***MODIFICATION REQUEST:
New Macquarie University Hospital
2 Technology Place, Macquarie Park
(MP06_0172 MOD 7)***

***Closure of Technology Place at Talavera Road,
associated road works and amended/new
signage***

Director-General's
Environmental Assessment Report
Section 75W of the
Environmental Planning and Assessment Act 1979

February 2012

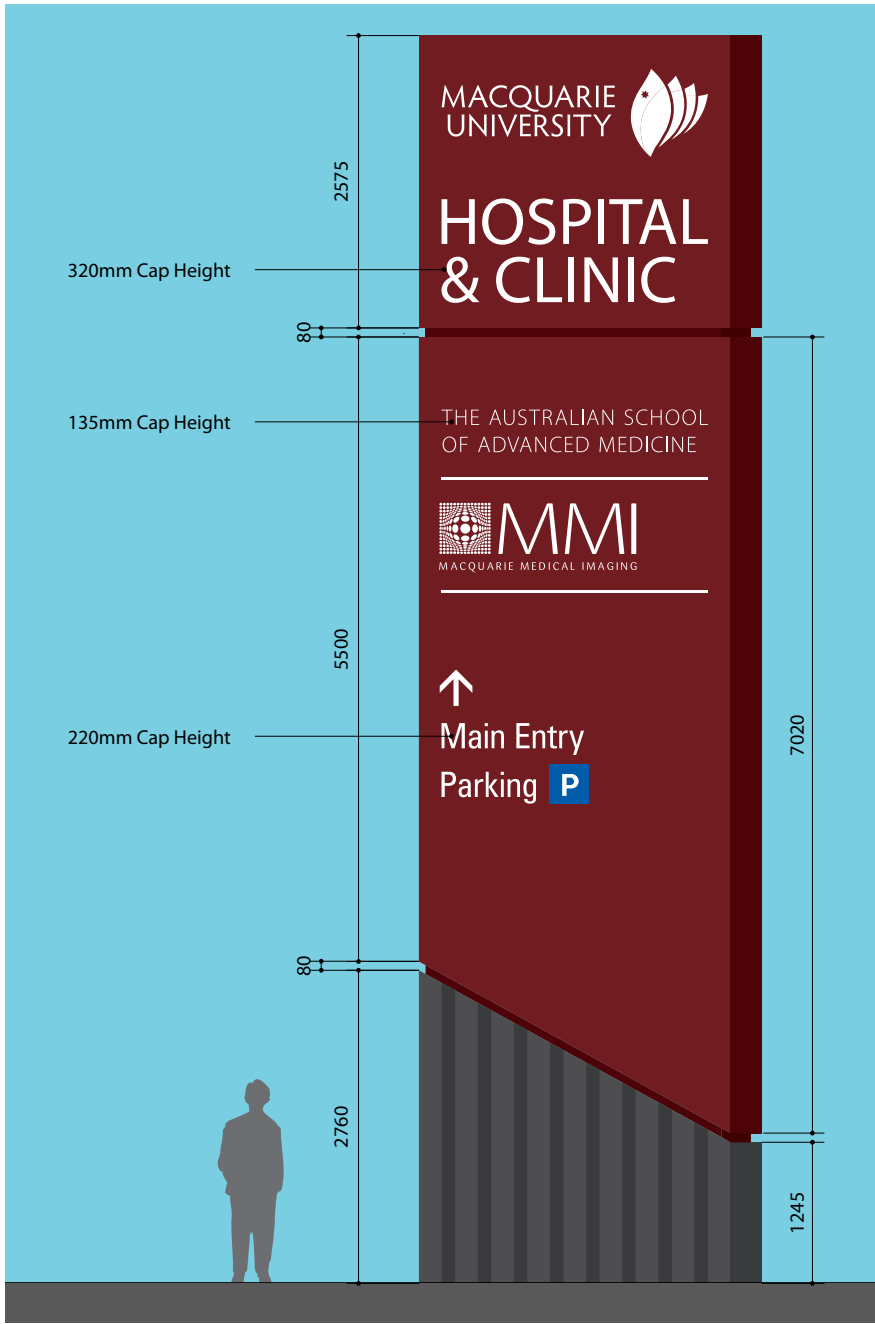
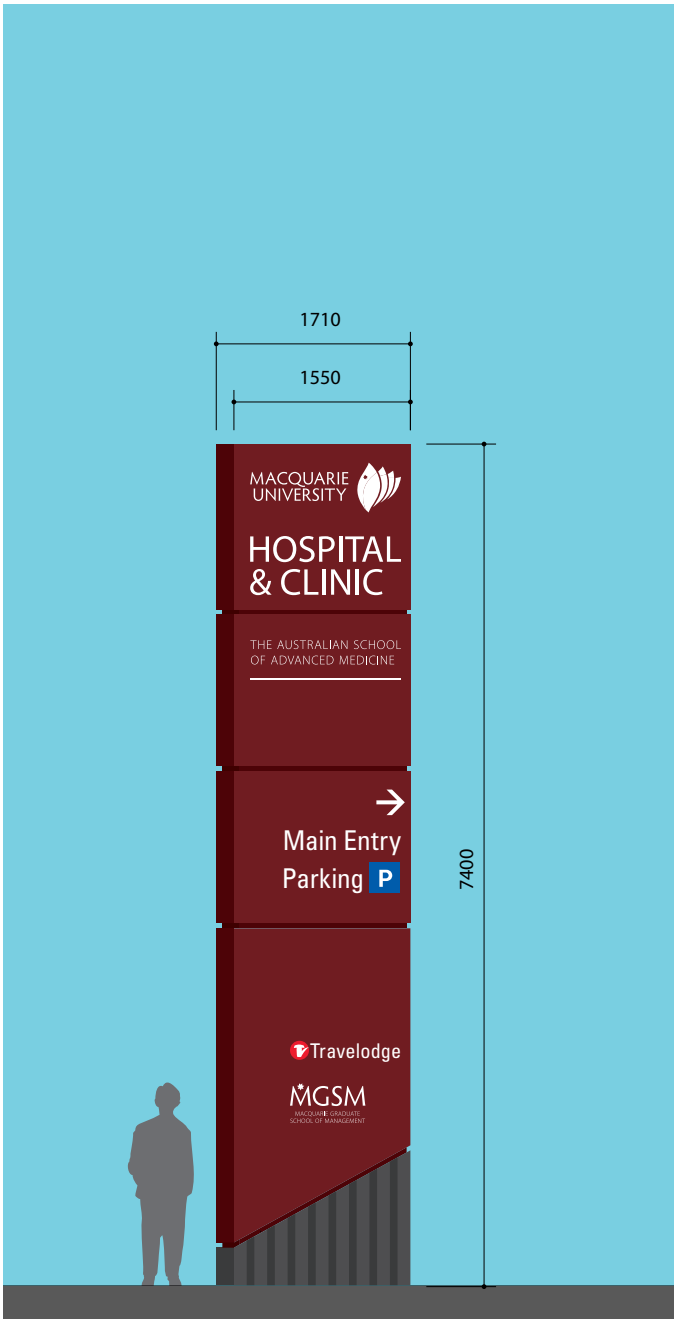
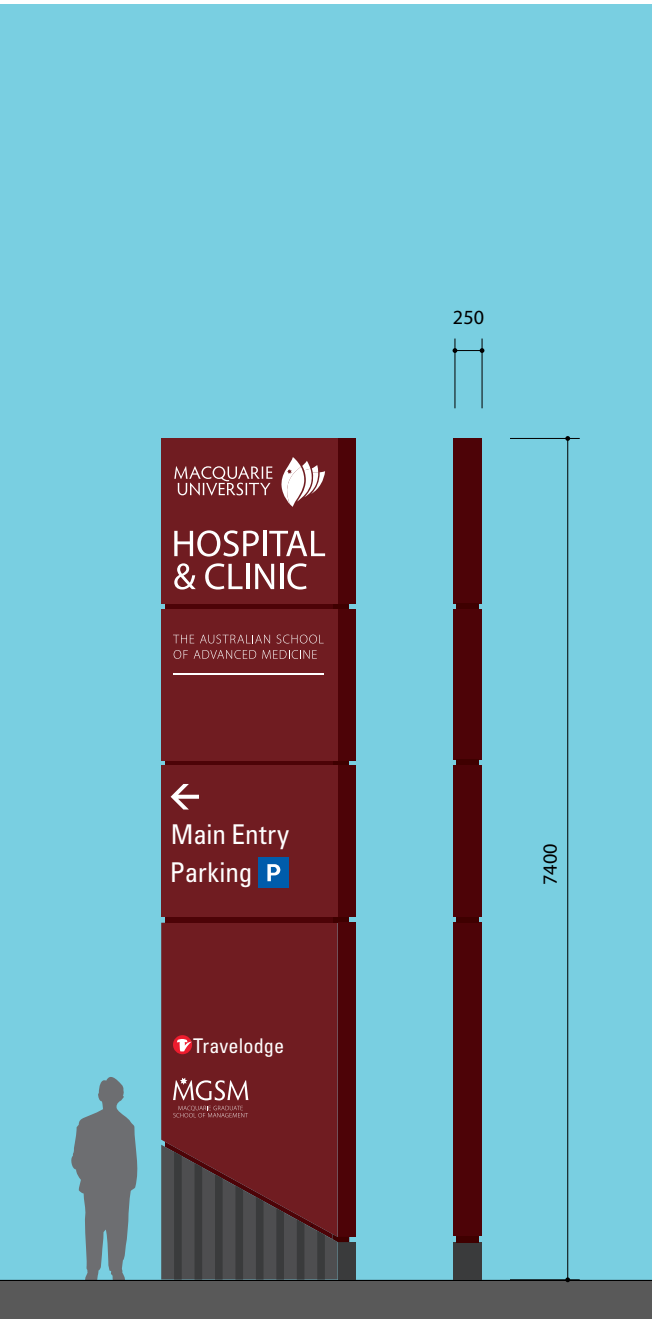
Sign No.		Details of sign	Department's consideration
1	Sign 1 – Main Entry Sign	Amended	Replace the northern and southern panels to reflect the location of the main entry and parking resulting from the closure of Technology Place. It is also proposed to make minor changes to the graphics on the signage panels, including the display of the MMI (Macquarie Medical Imaging) logo.	The department does not object to the proposed replacement signage panels given that the location, height and form of the sign will remain as approved, with only minor graphical and wording changes proposed.
2	Sign 2 – Talavera Road and Research Park Drive intersection	Proposed new sign	The proposed sign is required to direct staff, patients and visitors to the main entry and car park via Research Park Drive. The new sign is 7.4 metres in height, 1.7 metres in width and 0.25 metres in depth.	A new sign is required in this location to reflect the new access to the hospital and clinic due to the closure of Technology Place. This sign serves a similar purpose to the main entry sign and the department does not object to a height of 7.4 metres to ensure the

prominence of the hospital and direction to the main entry and parking. The proposed sign is considered compatible with the character of the area which is largely commercial in nature, and will have no adverse visual impacts.
3	Sign 3/Sign C11	Amended	The sign is proposed to be relocated from its existing approved position (c11) and the panels are proposed to be amended to reflect the changed traffic conditions resulting from the closure of Technology Place. The sign has dimensions of 3 metres in height 0.75 metres in width and 0.15 metres in depth.	The department does not object to the relocation of this sign and graphical/wording changes.
4	Sign 4	Proposed new sign	The proposed sign is required to indicate the location of hospital parking, clinic parking and the hospital set down and pick up further south on Research Park Drive due to the potential redistribution of vehicle movements to the route as a result of the closure of Technology Place. The new sign is 2.4 metres in height, 0.6 metres in width and 0.15 metres in depth.	The department does not object to the new sign in this location to provide clear directions to the hospital parking and the clinic parking and set down/pick up area. The proposed height of 2.4 metres is considered appropriate in this location and compatible with existing signage in the area.
